KITTITAS COUNTY

MEMORANDUM

SUBJECT: Craig Land Company Short Plat SP-09-00019

CRAIG LAND COMPANY SHORT PLAT
 A PORTION OF THE SOUTH 1/2 OF SEC. 35, T.21N., R.14E., W.M.
 KITTITAS COUNTY, WASHINGTON

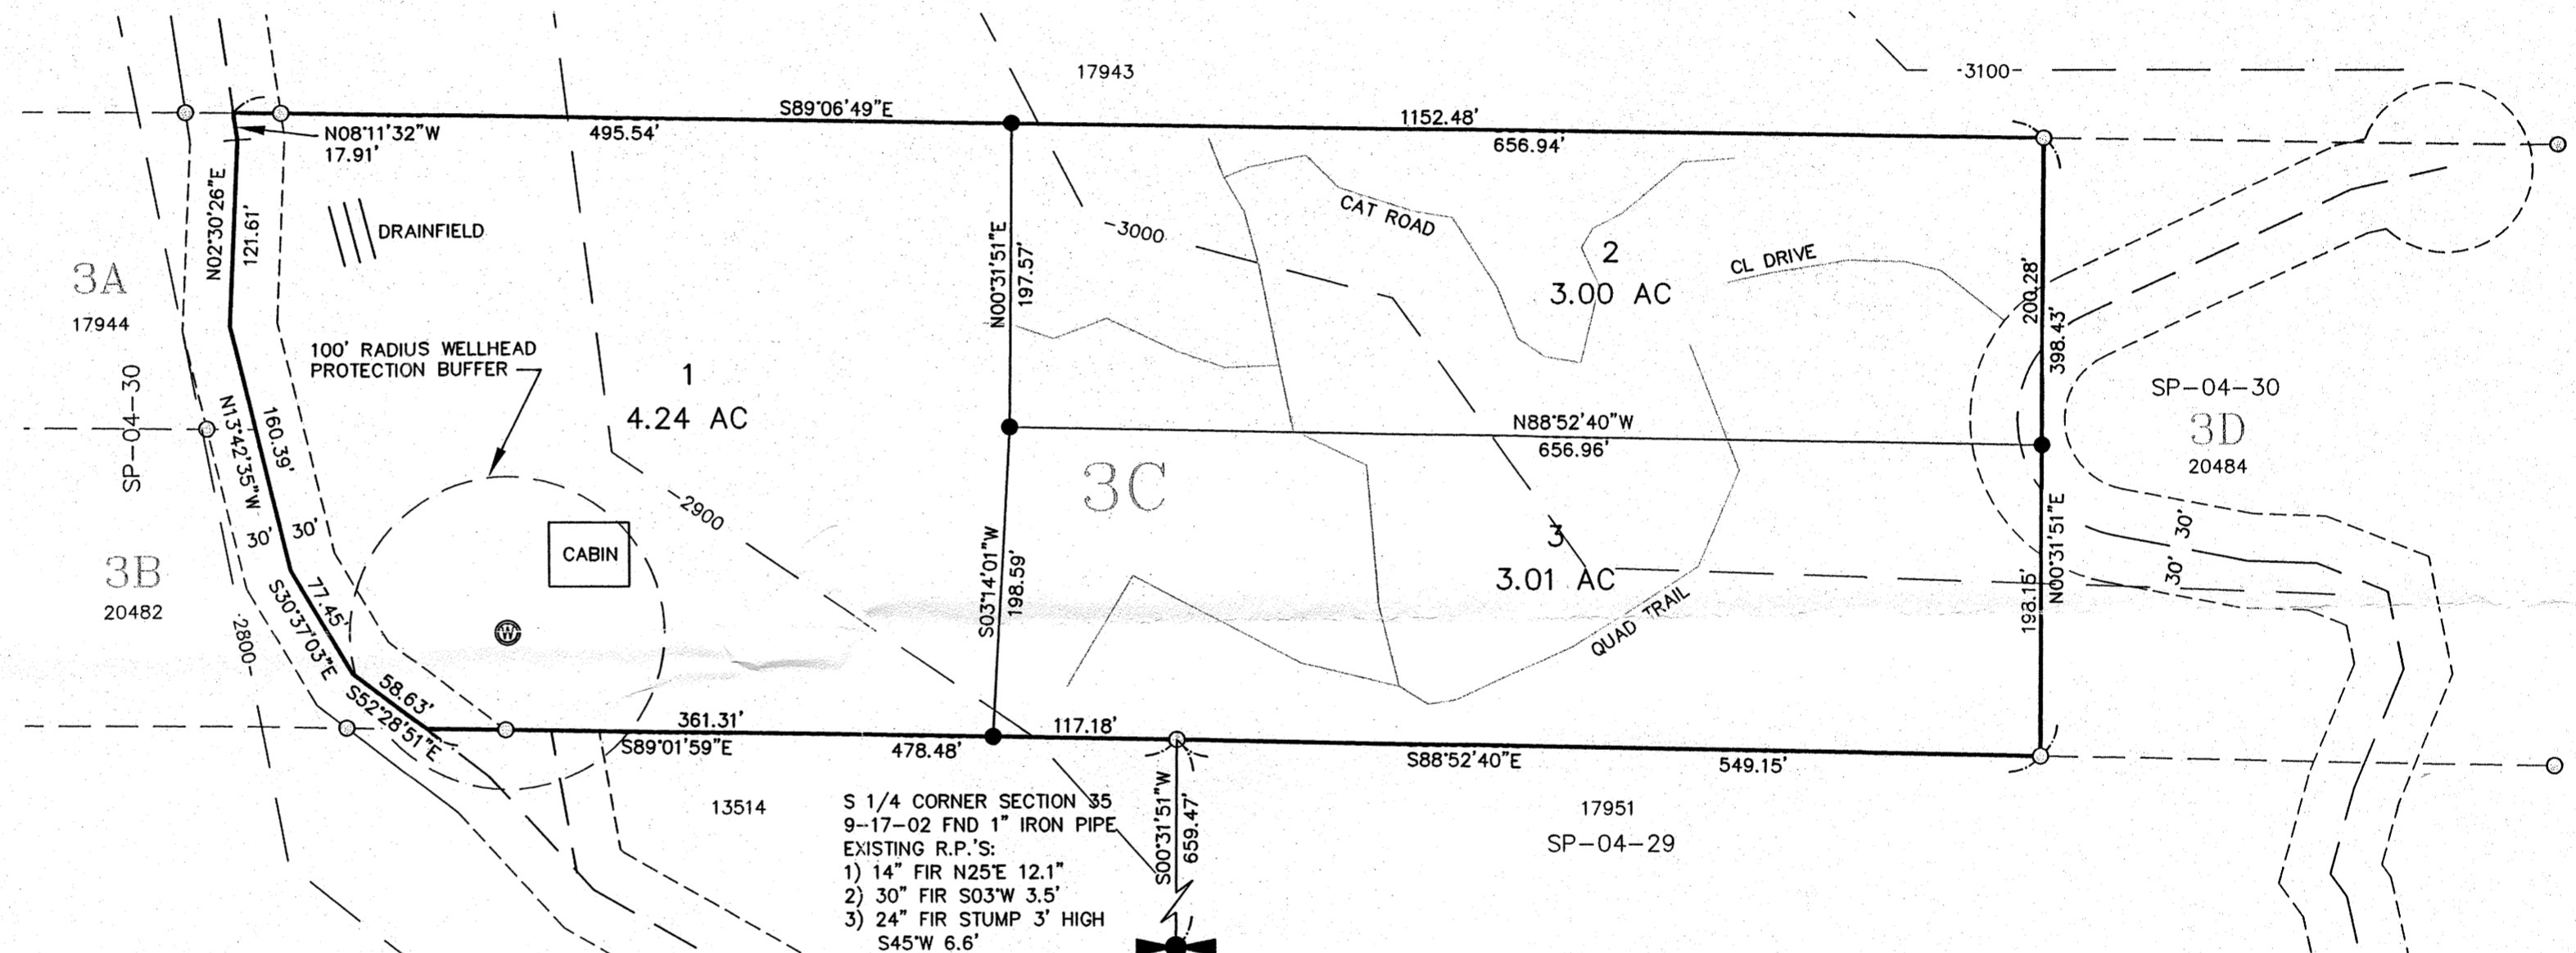
3. Private Road Improvements: Access from SR 903 to a cul-de-sac at the end of both Thunder Road and the side road off Ridgecrest Road shall be constructed as a Low-Density Private Road. See Kittitas County Road Standards, 9/6/05 edition.

- a. Access easements shall be a minimum of 60' wide. The roadway shall have a minimum width of 20', with 1' shoulders, for a total width of 22'.
 - b. Minimum centerline radius will be 60'.

- c. The surface requirement is for a minimum gravel surface depth of 6".
 - d. Maximum grade is 12%.
 - e. Stopping site distance, reference AASHTO.
 - f. Entering site distance, reference AASHTO.

- j. All easements shall provide for AASHTO radius at the intersection of county road.
 - k. A paved apron shall be constructed at the intersection of the proposed private intersection and the county road right of way.

4. Cul-de-Sac: If the existing cul-de-sac on the new Lot 1 will be used as the turnaround for this short plat, it shall be shown within a 110' easement and constructed as required below:
A cul-de-sac turn-around having an outside right-of-way or easement diameter of at least 110 feet shall be constructed at the closed end of all dead-end roads serving 3 or more lots. The driving surface shall be at least 96 feet in diameter. Cul-de-sacs must also conform to the requirements specified by the 2006 International Fire Code. Contact the Fire Marshal regarding any additional cul-de-sac requirements.
